STERLING RANCH FILING 4

LANDSCAPE PLAN

FINAL LANDSCAPE PLAN MINOR MOD

V1_Landscape Plan.pdf Markup Summary

LANDSCAPE PLAN

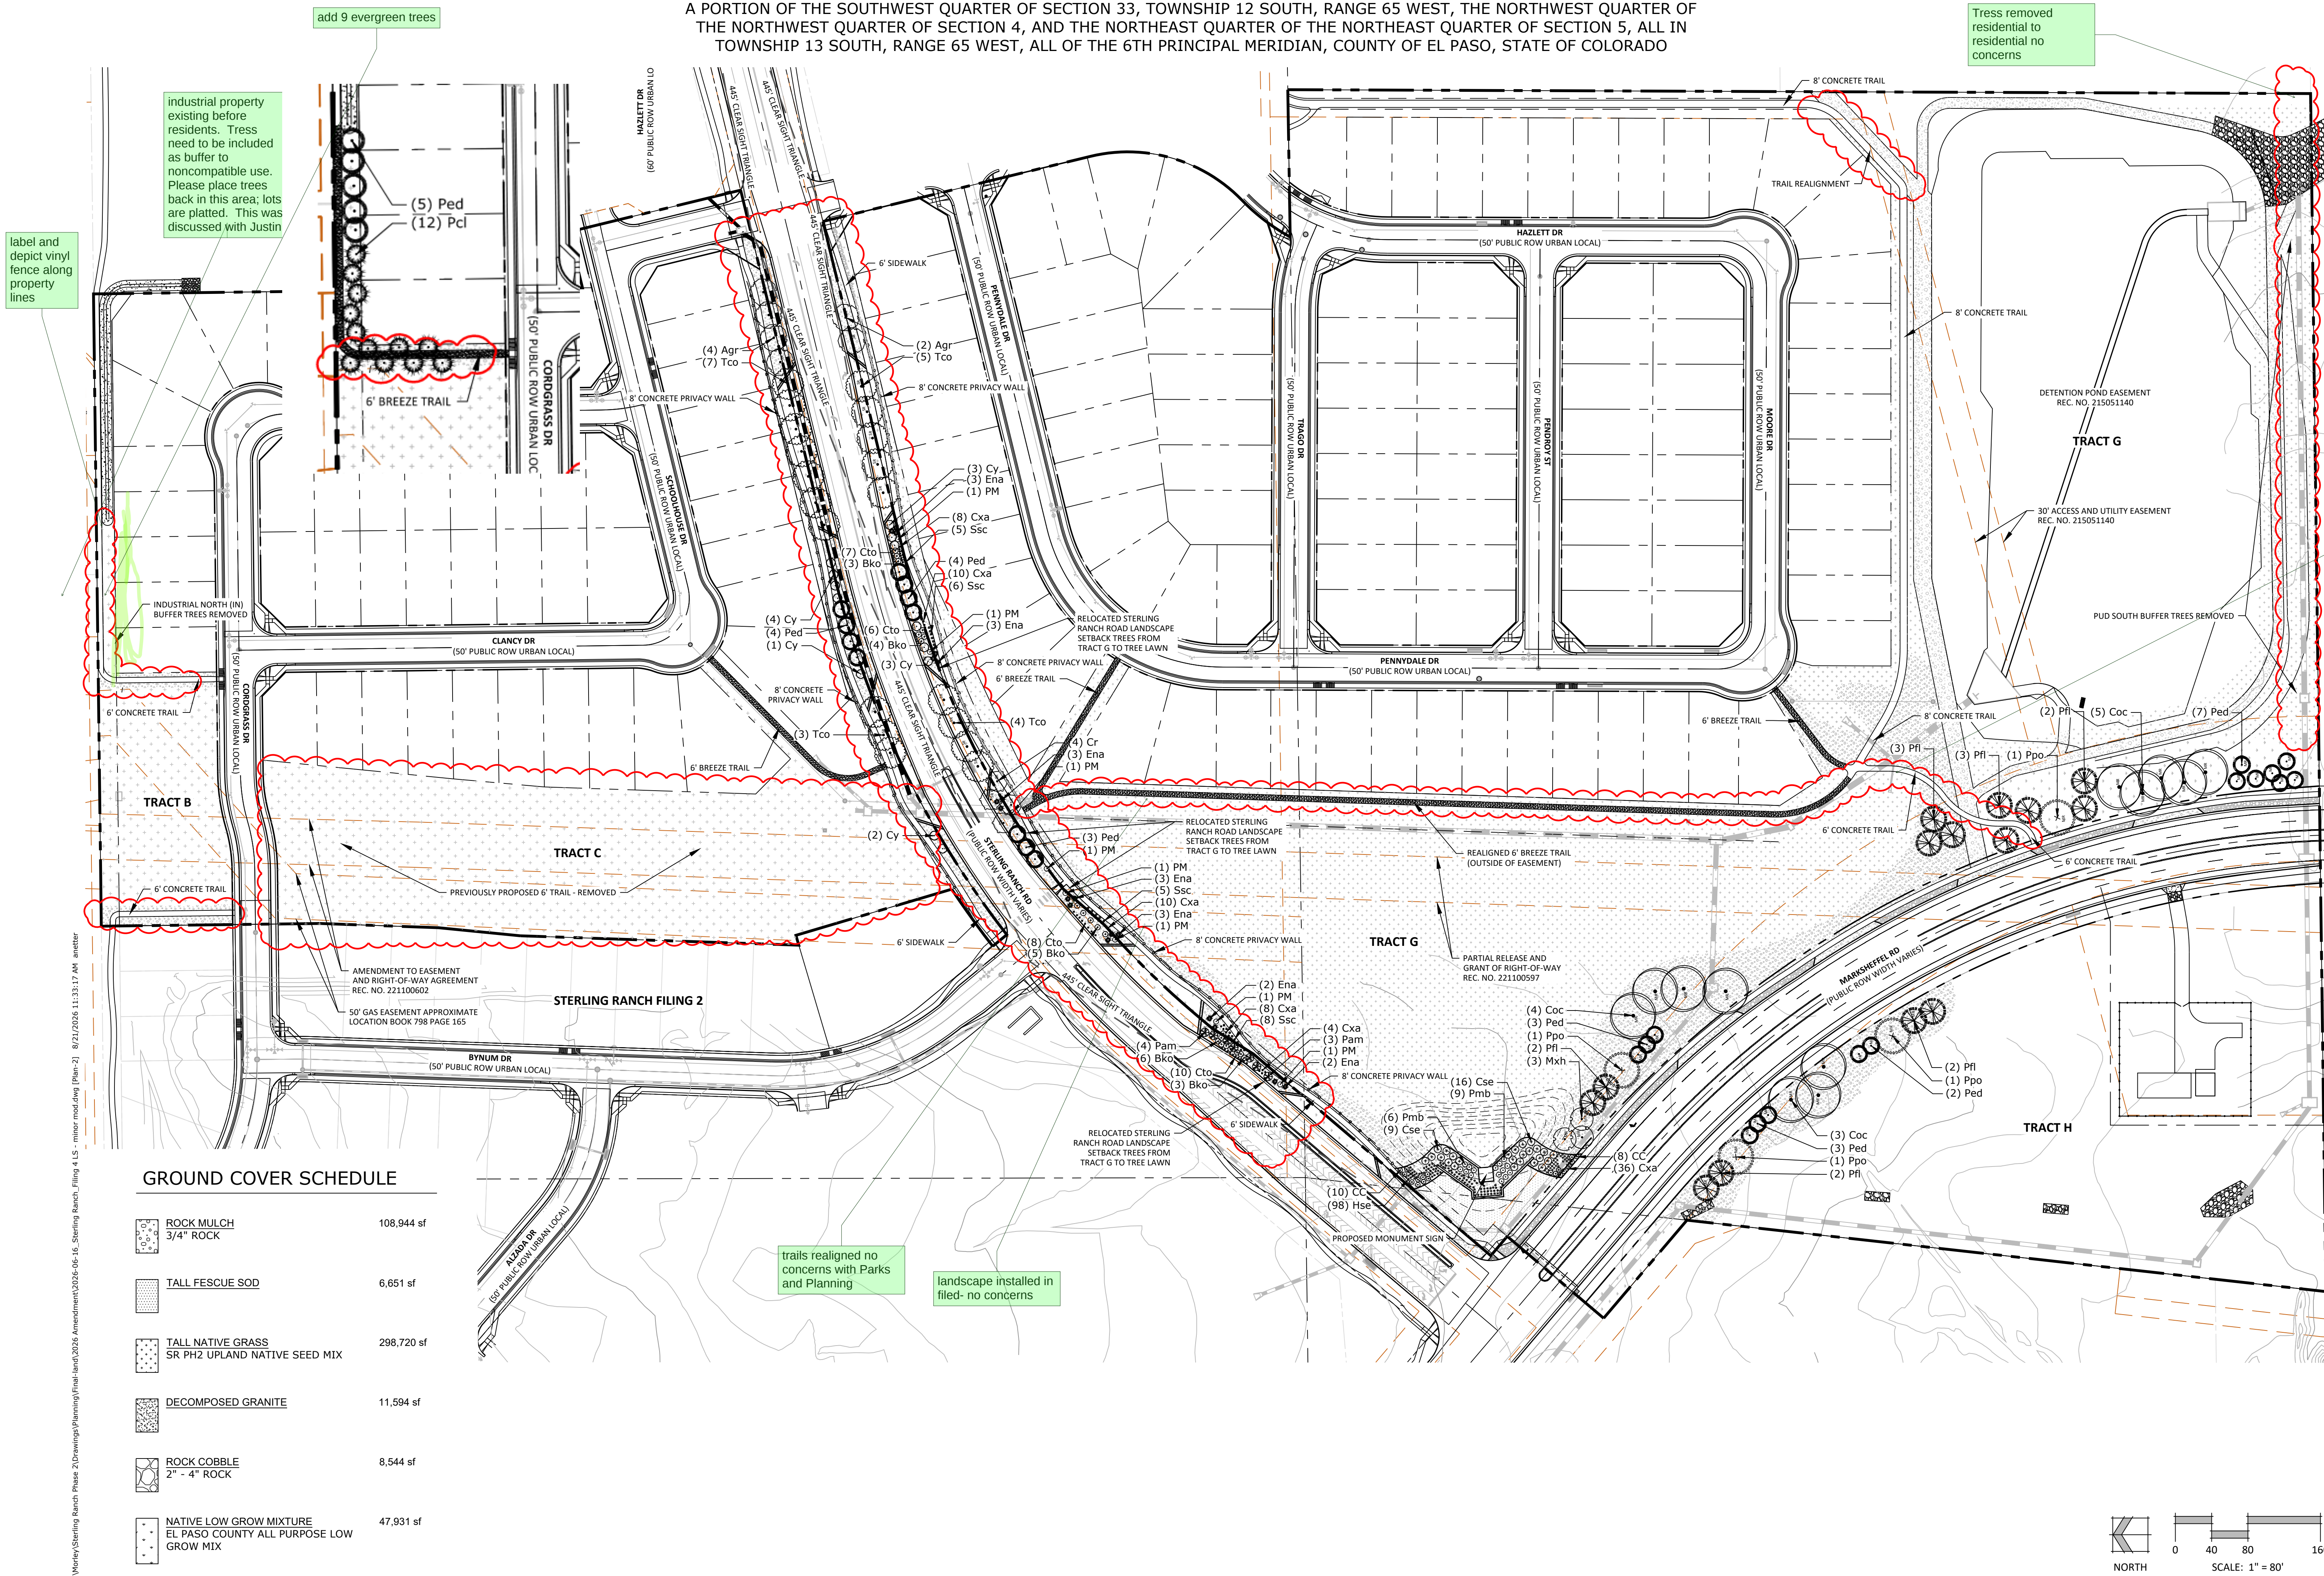
In regard to the Sterling Ranch Road landscape which is the communities main thoroughfare thus impacting the overall community. Please provide an alternative and justify said alternative or meet the Code. This was not previously discussed with staff.

### LANDSCAPE COVER, NOTES, & DETAILS

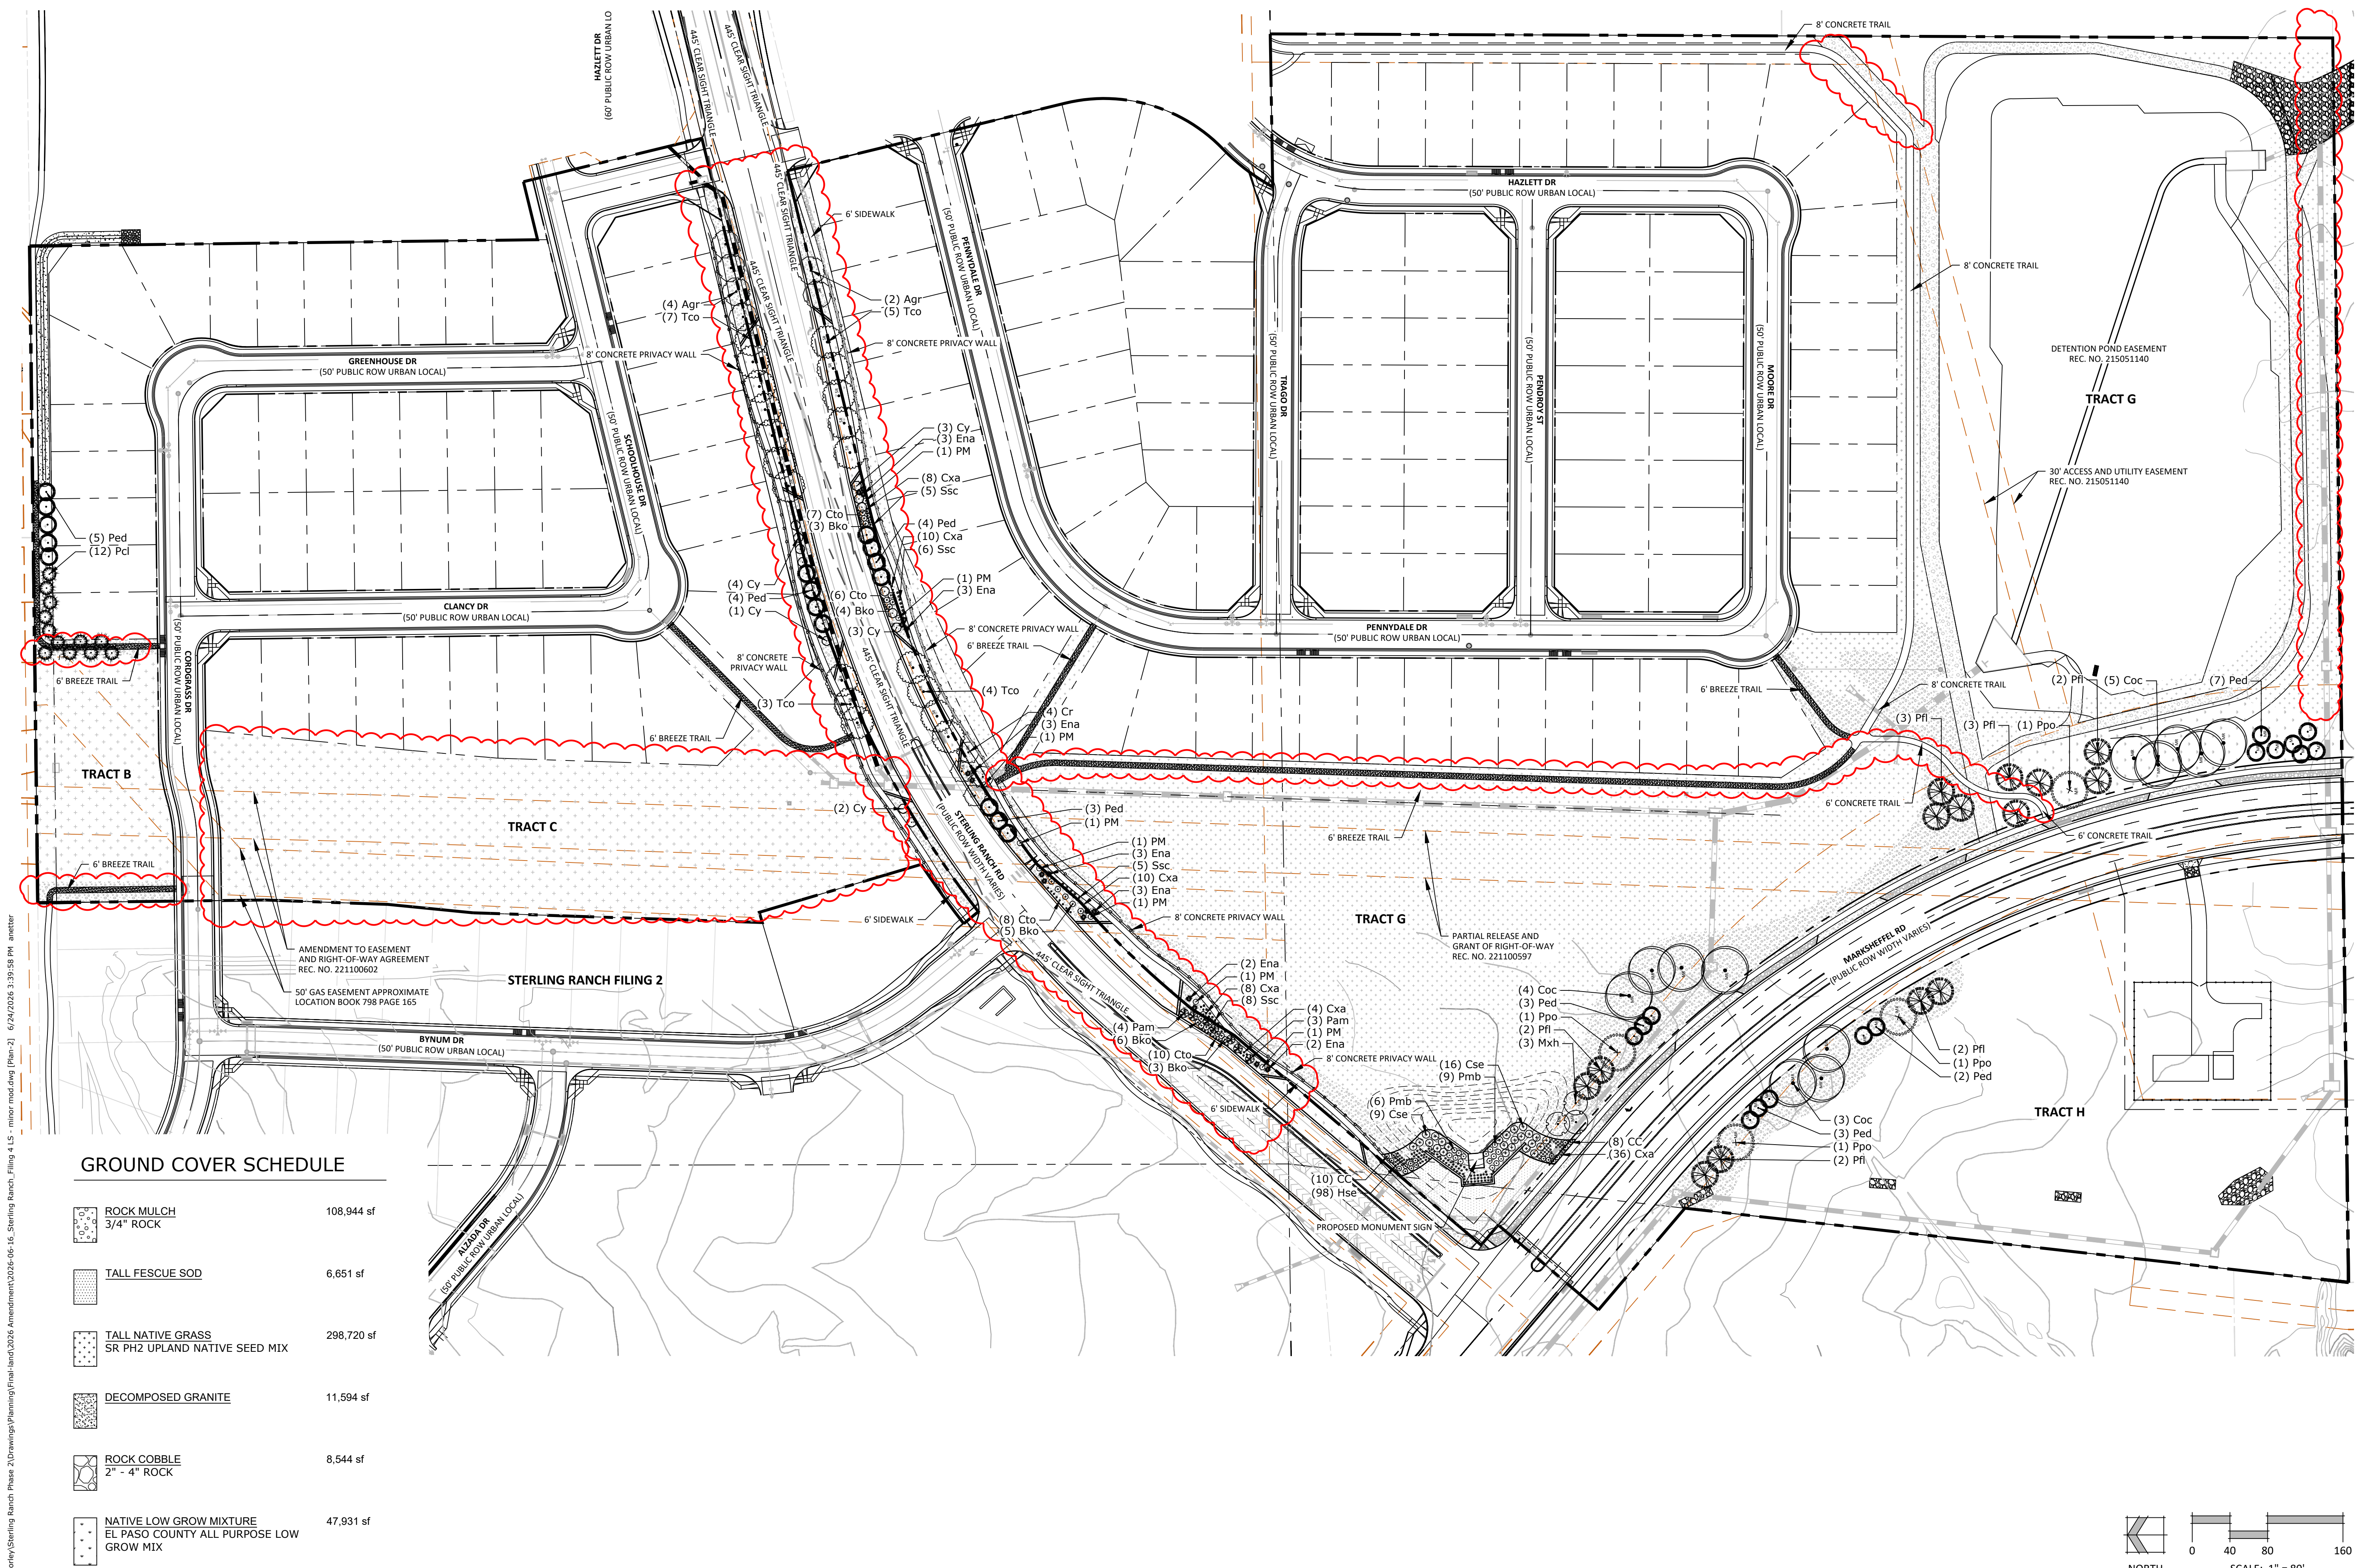
It is not clear all the areas of landscape removal or changes based on what was submitted.

Clearly label what has been modified

please provide all the sheets 1-9 of the landscape plan so a comparison can be made. Are more areas being reduced?
